From:
Sent: 30 November 2025 22:14
To: Louise Bearcroft; DC Admin
Subject: Objection Re: Planning Application 2025/61/92713 and 2025/44/92737

Planning Application 2025/61/92713

Minimum Separation Distance

Client PPJ Developments
Project 2539 - Moor Lane - Residential
Title GA Plans & Elevations HT05

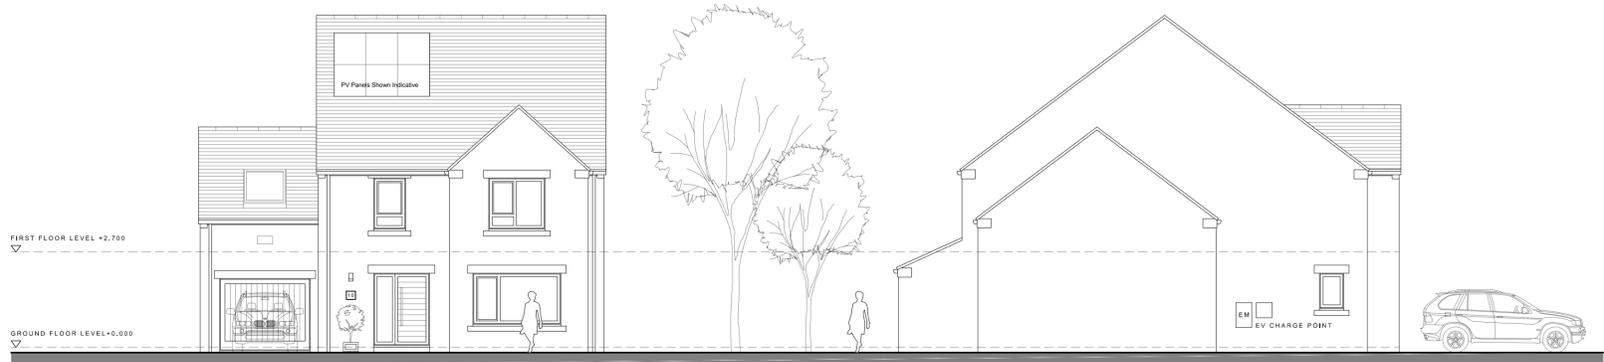
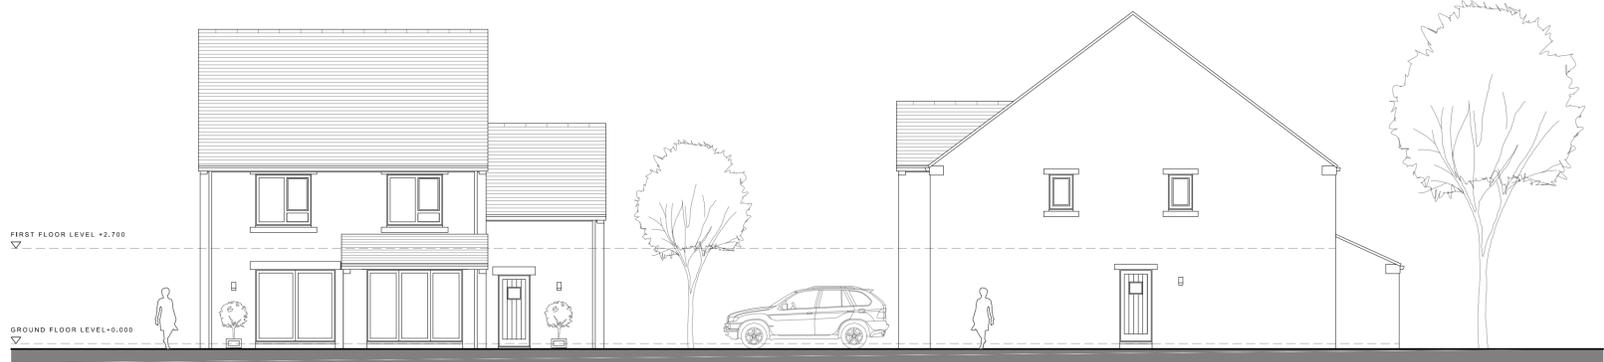
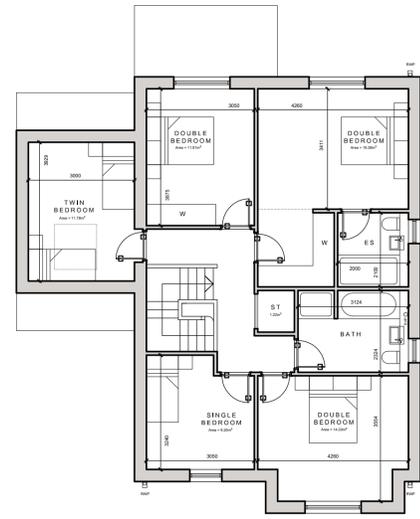
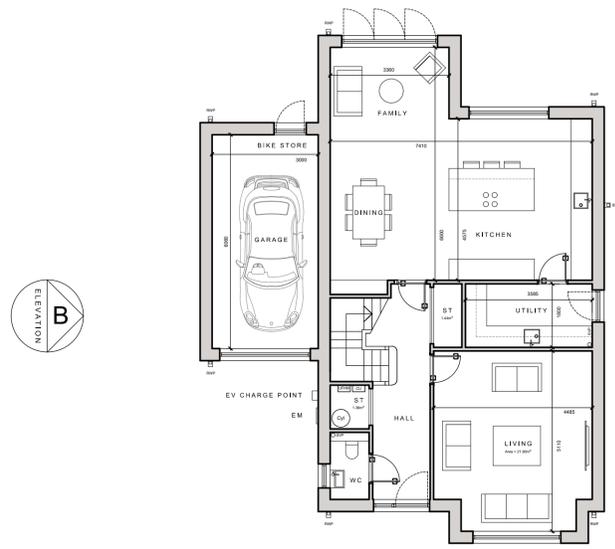
The separation distance between 21 Summerdale and Plot 10 is less than the minimum specified in Kirklees SPD's.

21 Summerdale has a habitable lounge window looking out onto the development Plot 10's boundary. Plot 10 has two non habitable bathroom windows and a doorway in the wall nearest this existing residence. **Therefore the minimum separation distance between Plot 10 and 21 Summerdale should be 12 metres.**

This current planning application is for 10 far larger houses and therefore all the houses are more cramped in and have been moved further east, closer to our boundary. There is only a one metre wide footpath between Plot 10's house wall and our boundary fence. A doorway entrance/exit for Plot 10 is onto this footpath.

The distance between Plot 10's house wall and our existing house wall has been reduced yet again in these plans and is much closer than what was in the Outline Planning Permission 2023/92079(Approved) and 2022/92100 (Refused).

Also as Plot 10 has an entrance door in the western wall, which overlooks this existing dwelling, conservatory and garden, there will be a constant flow of people passing through this doorway, close to the boundary fence, which will result in loss of privacy to 21 Summerdale.

As can be seen, on the plans submitted with this application, the topography of Plot 10 is a lot higher than the topography of 21 Summerdale. This fact means that Plot 10, a large 5 bedroomed house, will be higher, combined with the fact that it is located closer than the allowable minimum distance, it will therefore overlook and overshadow the house, conservatory and gardens at 21 Summerdale.
